DRB CASE ACTION LOG (PREL & FINAL)

DRB Application No.: 05DRB-01751 (P&F)

Project # 1004475

Project Name: INDIAN FARM ESTATES

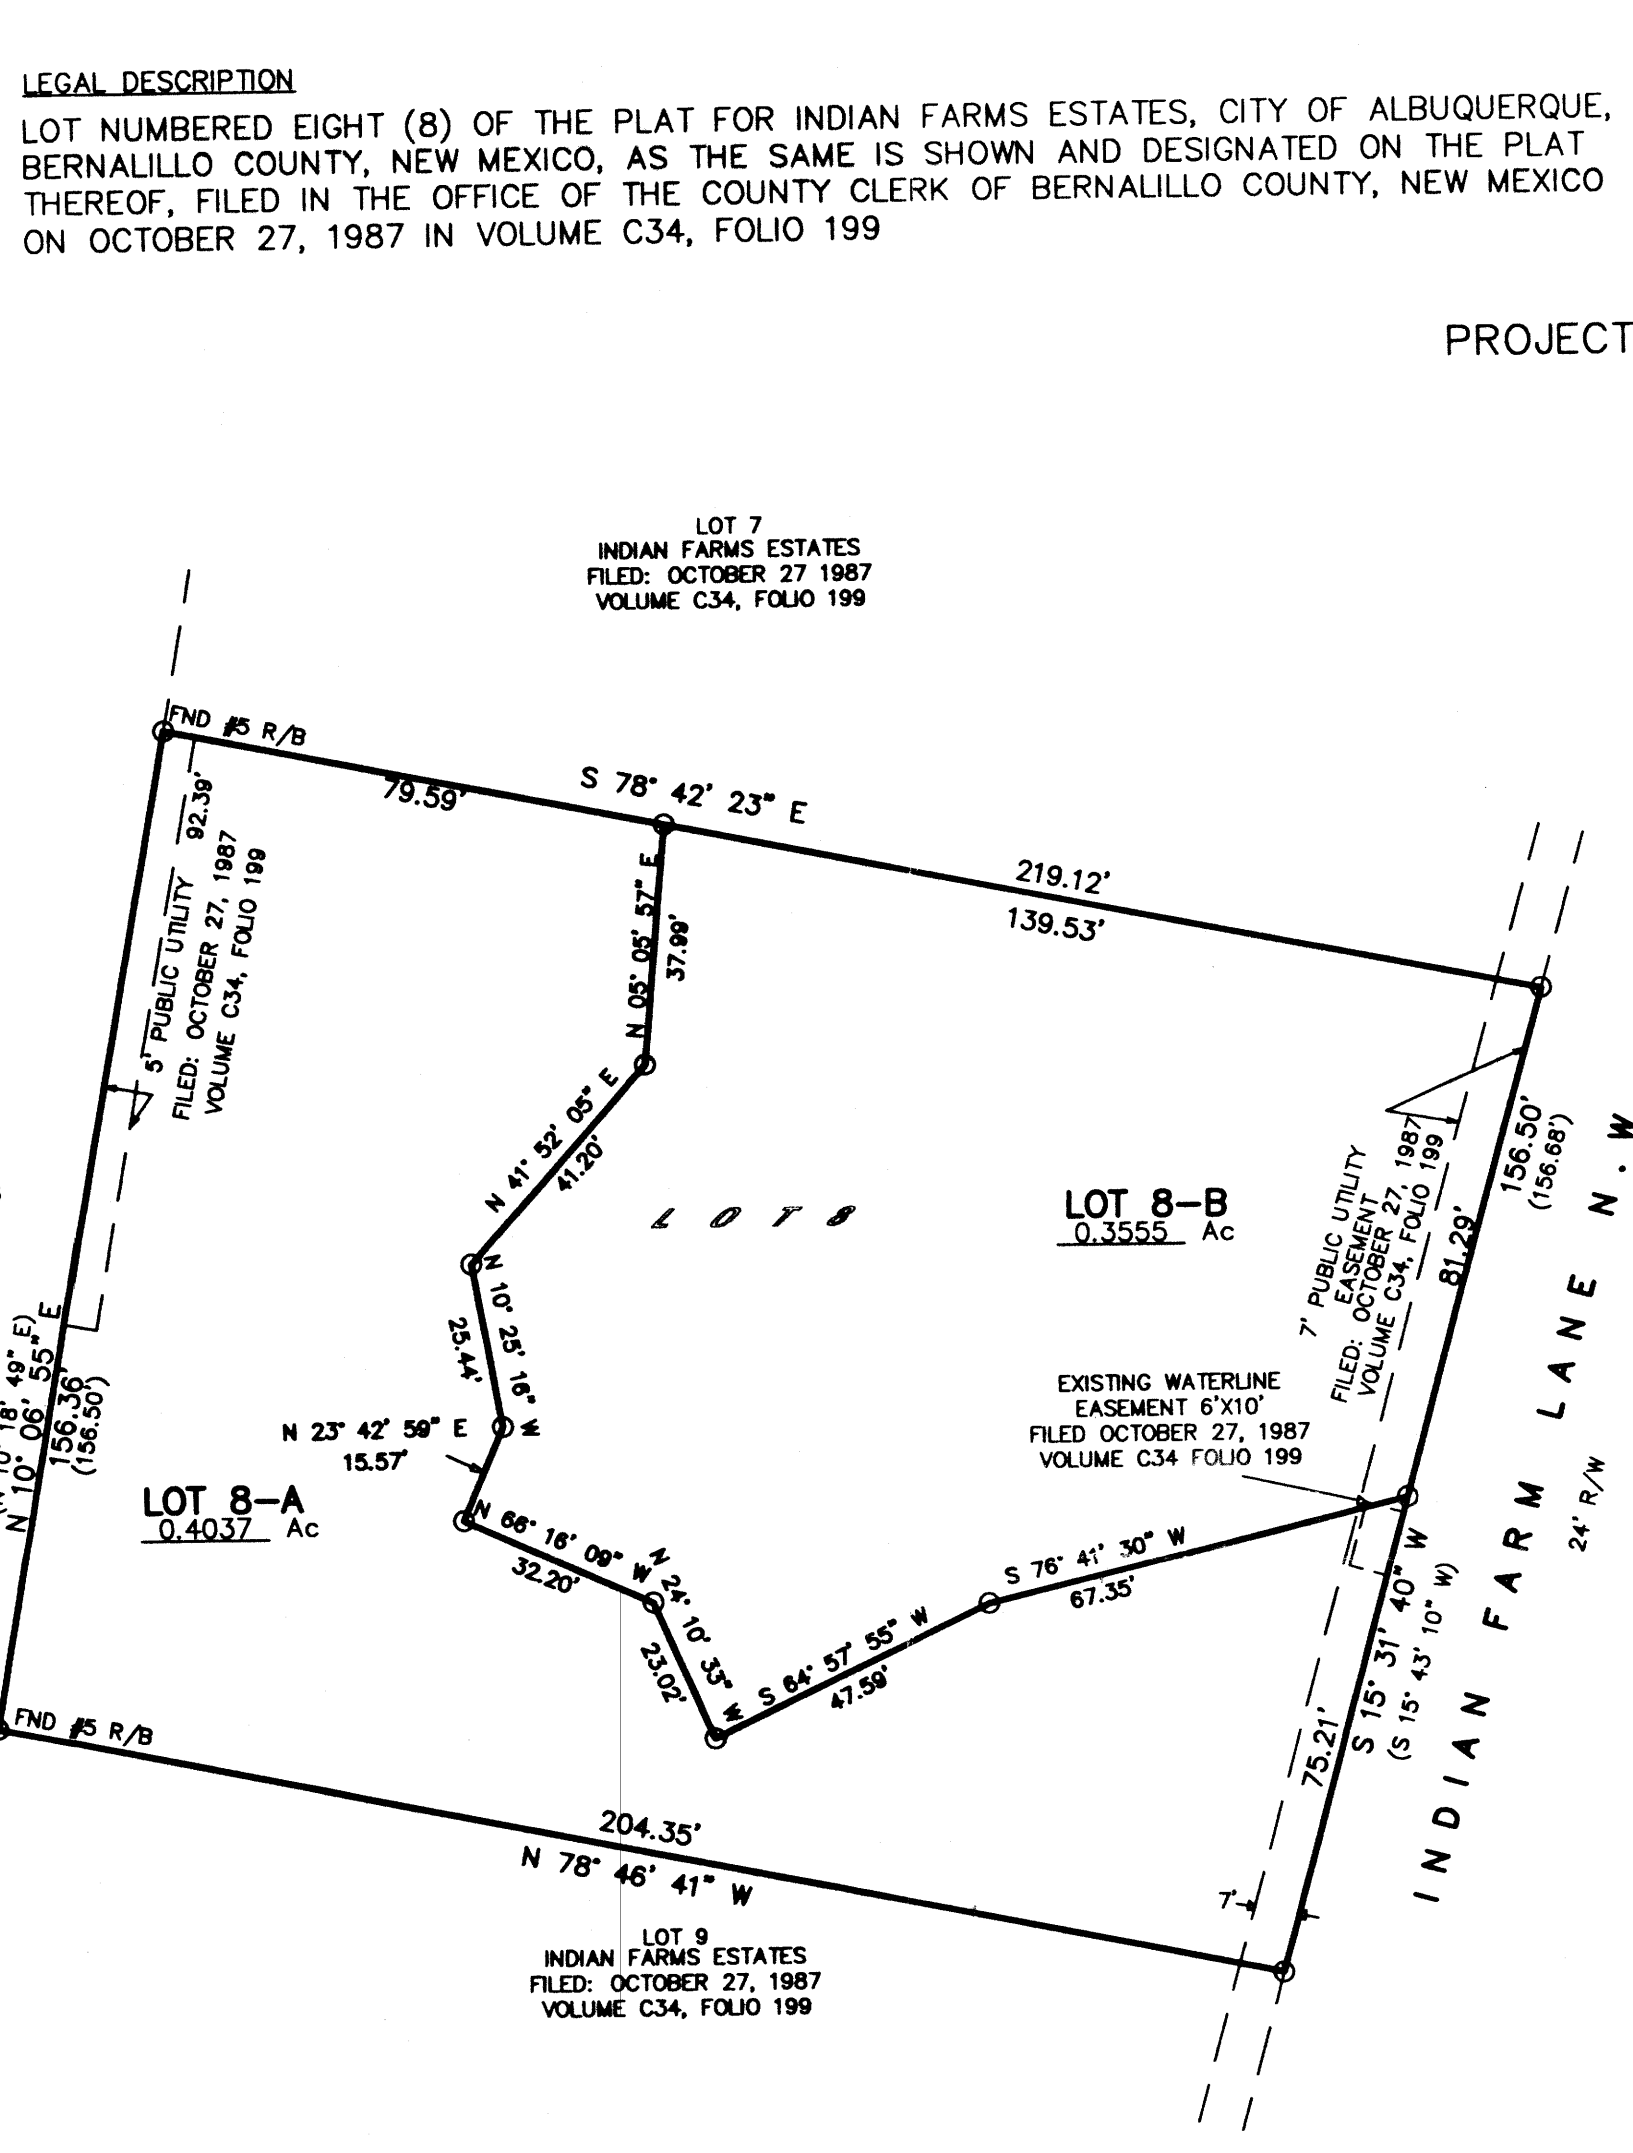
- UTILITIES: - Complete Sewer Tapping Permit for Lot P-B,
B.B. Add note to plat for lot 8-A.
12/05/05
- _____
- _____

1. I will take delegation of Final Plat and sign when new sewer service for existing house is completed.
2. Add the following note to Final Plat: "Water and sewer service stubs to Lot 8-A are not in place. Prior to development of Lot 8-A, service must be coordinated with the Water Utility Department."
